Objection to planning application No. 3/2023/0261

Address of Development: 8 Brookes Lane Whalley

Existing East Facing Elevation Scale 1:100

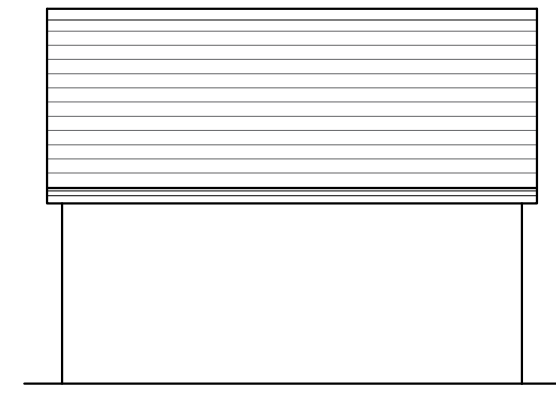
- ‘ This proposal is designed to facilitate a bespoke dwelling to assist with downsizing and future needs’ [REDACTED]
- The plan of the existing garage is inaccurate, it shows no window on the east facing elevation. Whilst this does not impact on the proposal it is further evidence of inaccurate information contained in the application.

PROPOSED GROUND FLOOR PLAN SCALE 1:50

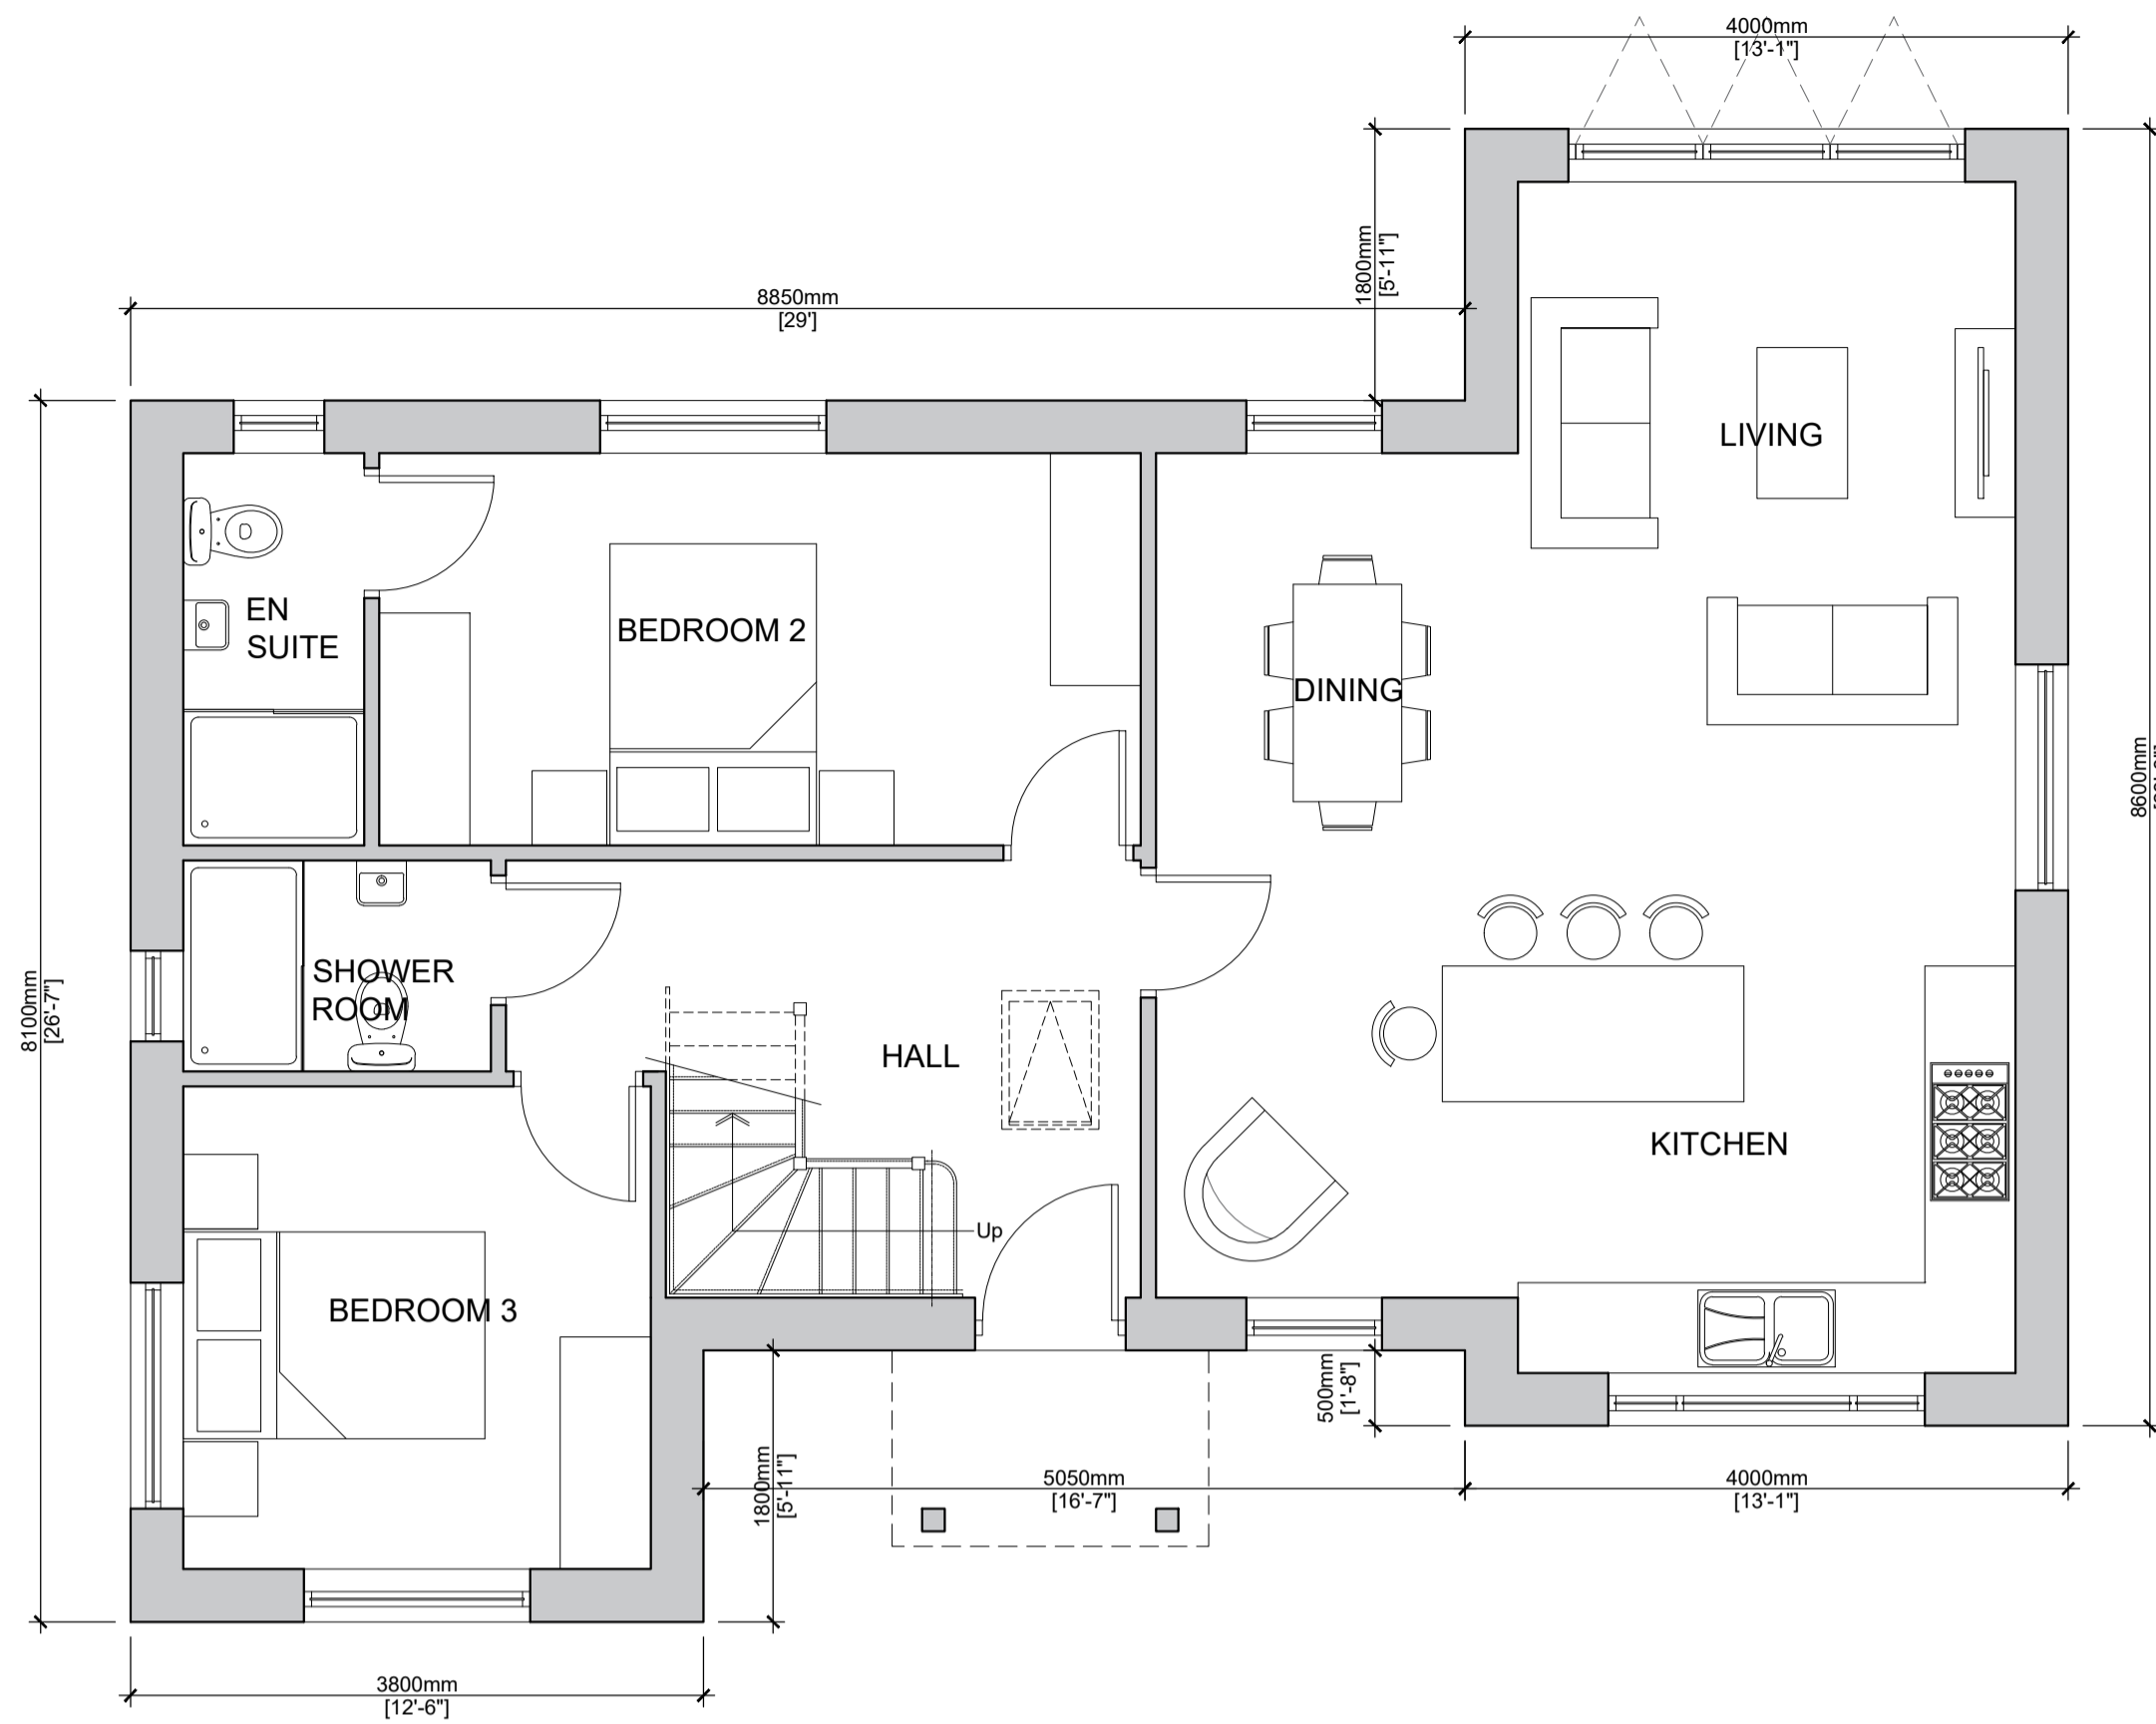
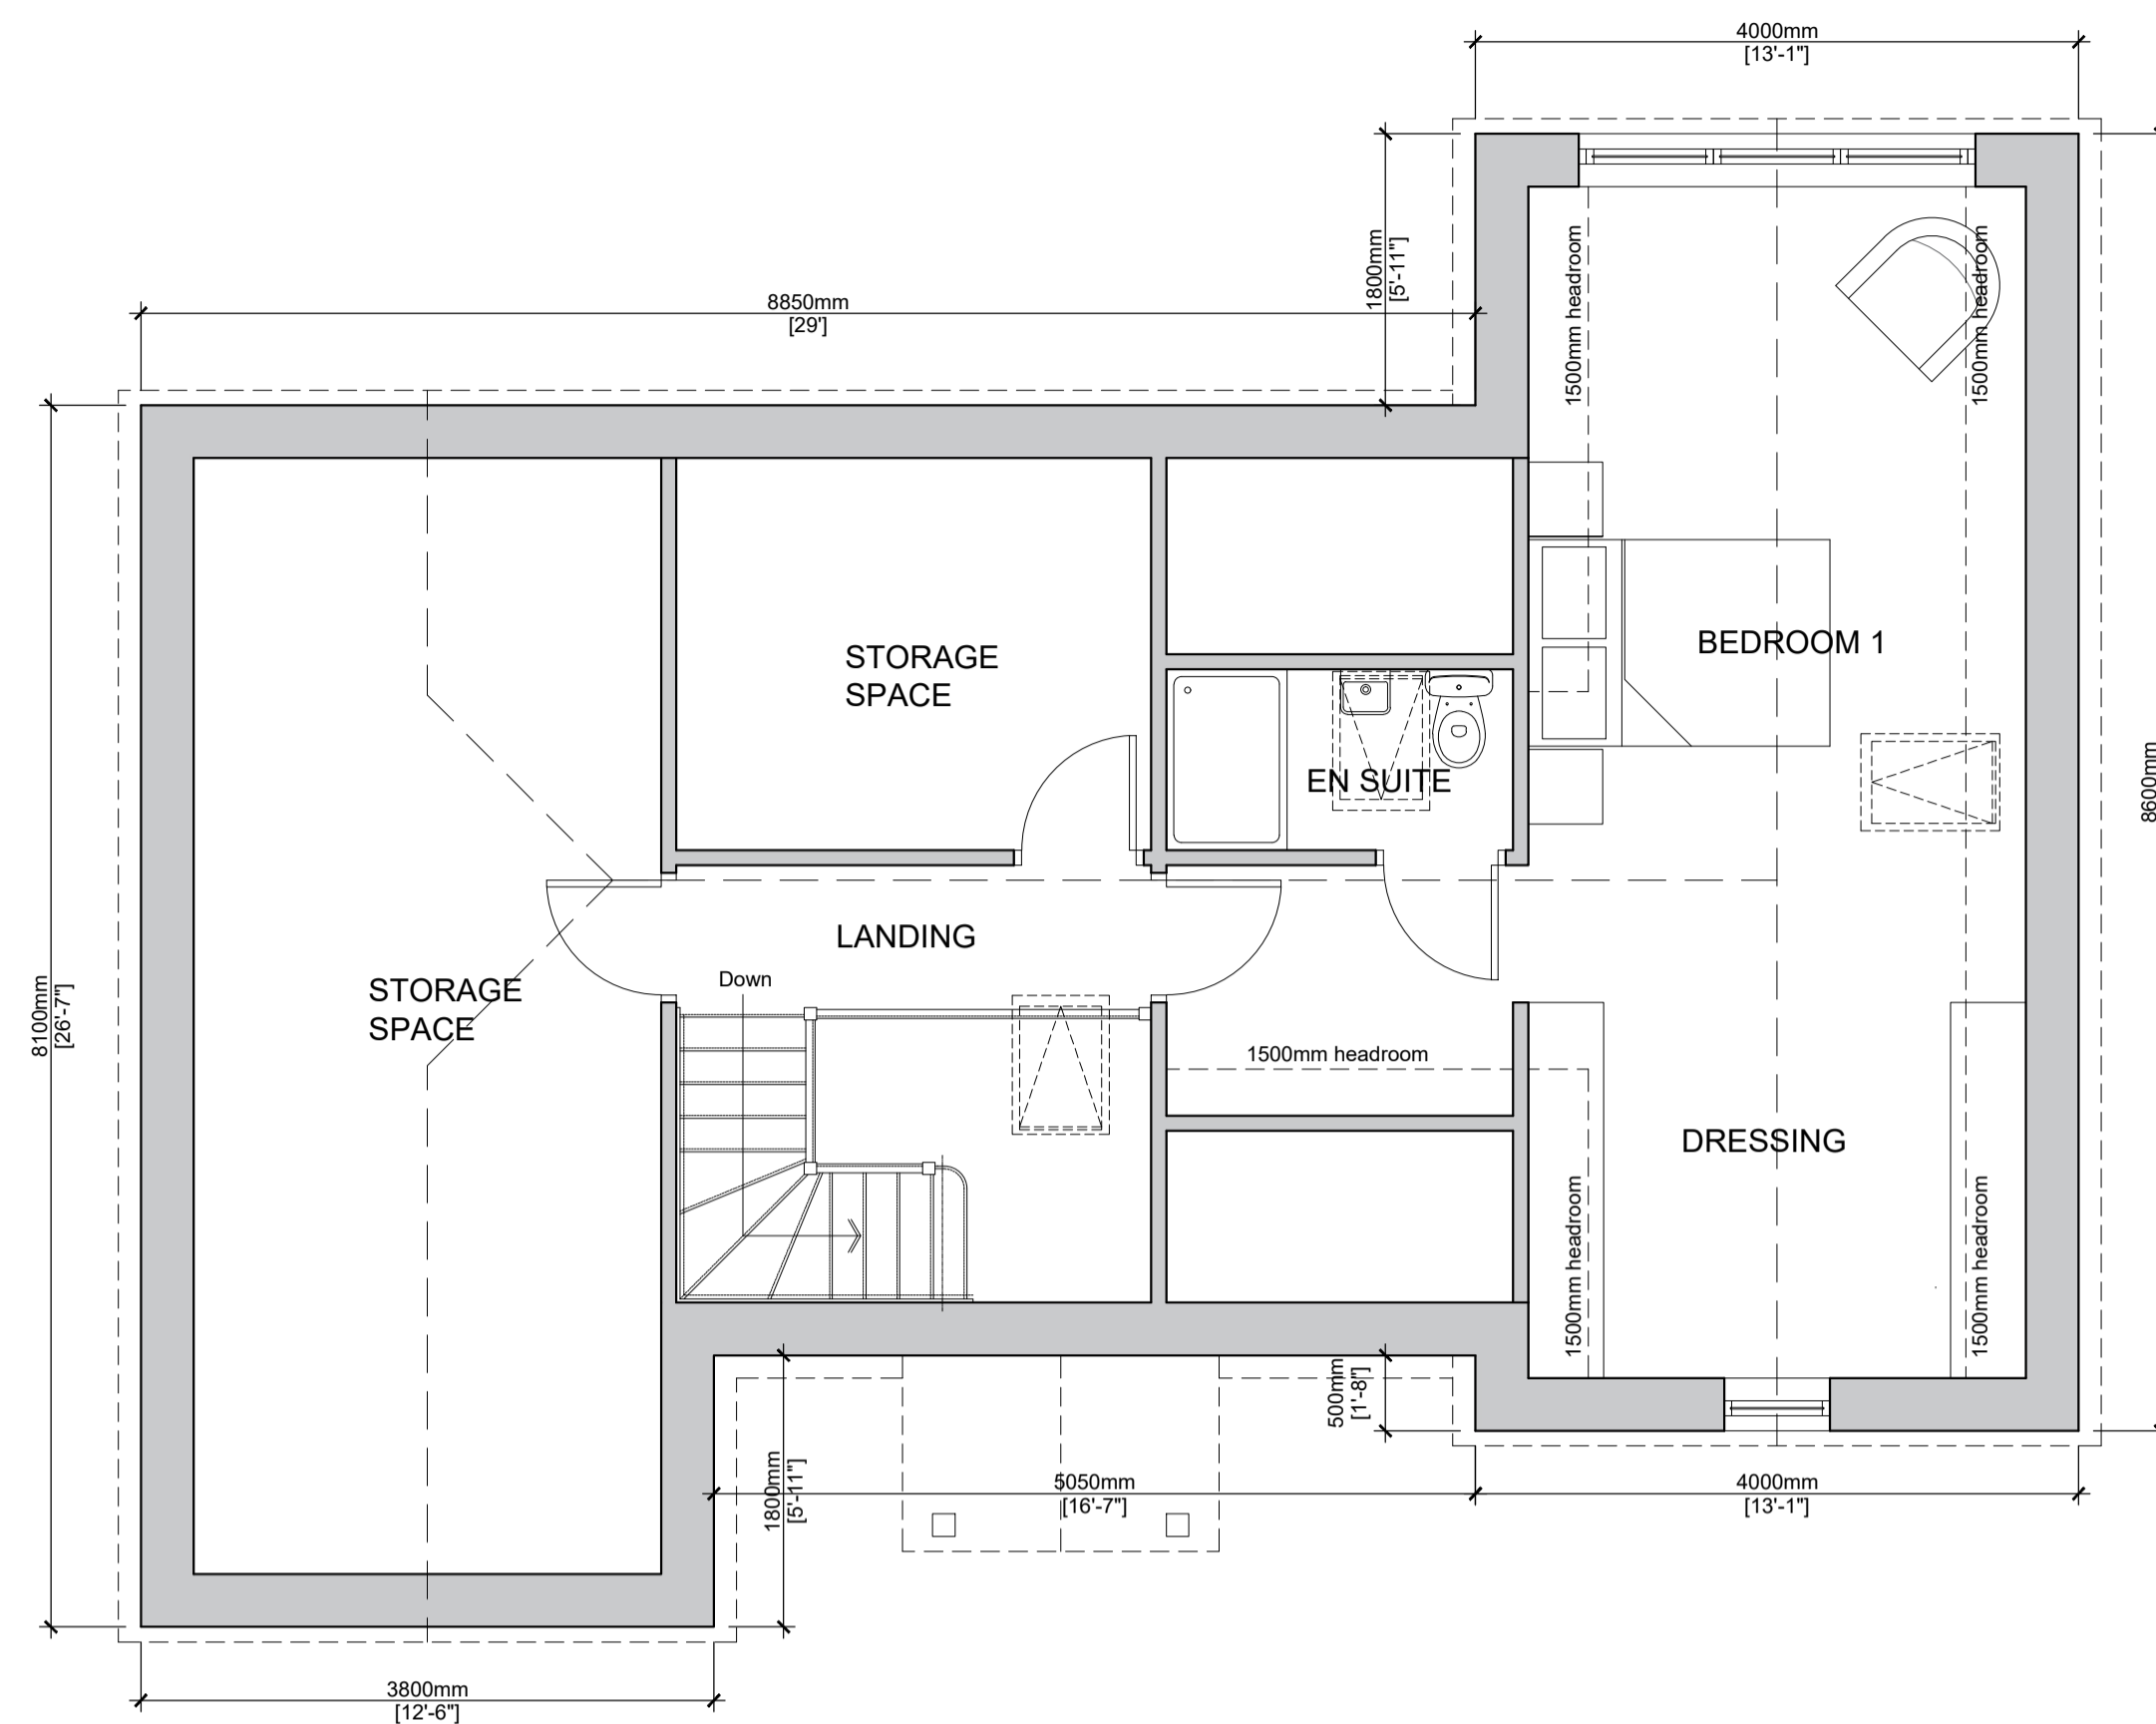
Whilst included with the application there is a tree survey and the application states it 'fully considers the mature trees that surround the site' this statement is untrue. The survey measurements included are inaccurate and the root protection area is larger than stated. We have had our own independent tree surgeon measure the mature beech tree and complete an arboricultural impact assessment (report included) The diameter of the trunk is at least 11 cm more than the 65cm stated in the application, therefore, the root protection area needs increasing by a further 1.32m. This would require the footprint for the development to be moved forward by at least this.

The ash tree situated alongside the beech was physiologically damaged in 2012 when the applicant applied for permission to remove overhanging branches. His tree surgeon removed the crown from the ash tree resulting in a decline in its physiological condition in the following years. The tree is however, structurally in good condition and we have been advised by the Ribble Valley Tree Protection Officer that it should remain in place as it supports and protects the beech tree adjacent to it. The root protection area for this tree should therefore, not be reduced by two thirds as stated in the applicant's tree survey. This tree's diameter is also more than stated in the survey again by at least 10cm so the unreduced root protection area would increase by 6.8m significantly impacting on the proposed footprint of the development.

PROPOSED SOUTH ELEVATION SCALE 1:50

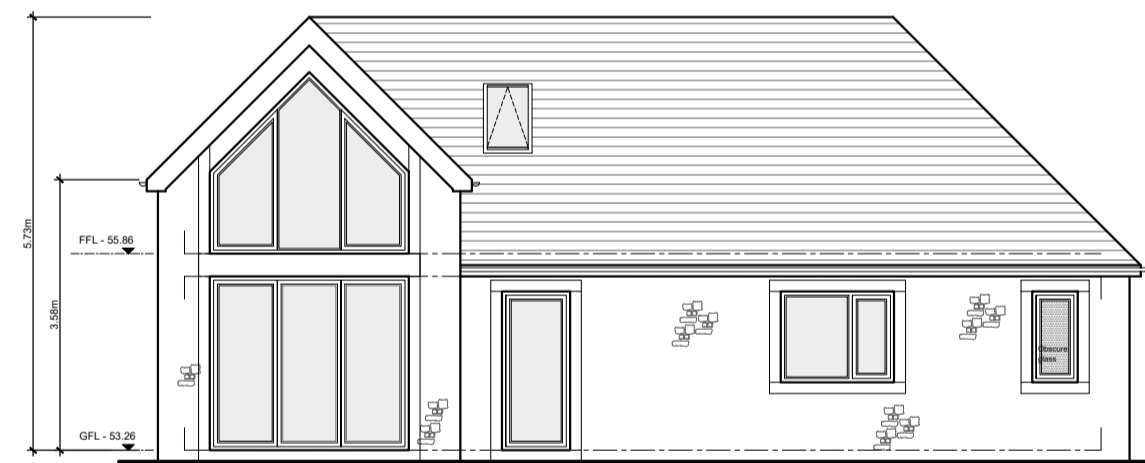
The proposed plans include a two floor glazed gable end on the south elevation, [REDACTED] [REDACTED] loss of privacy.

PROPOSED EAST ELEVATION SCALE 1:50

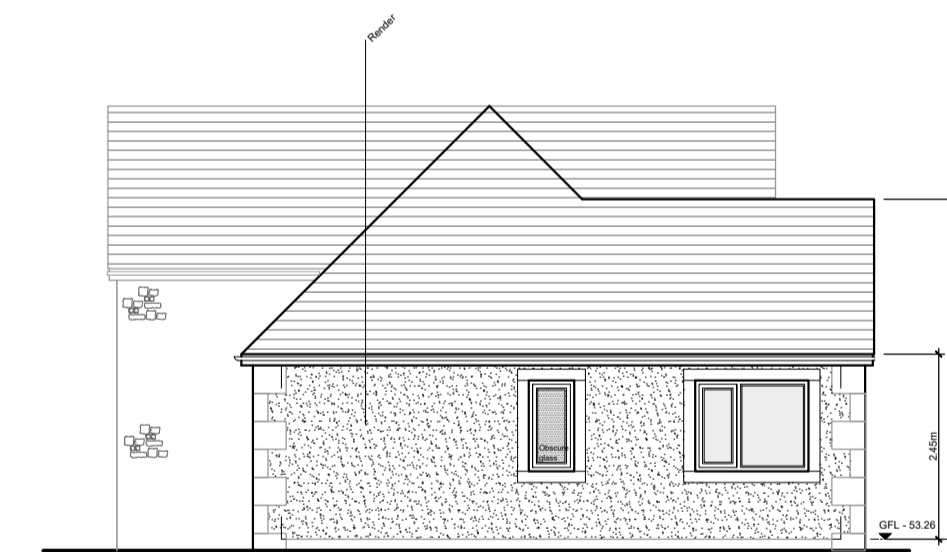
The east elevation of the proposal [REDACTED] and the noise pollution from the proximity to [REDACTED]
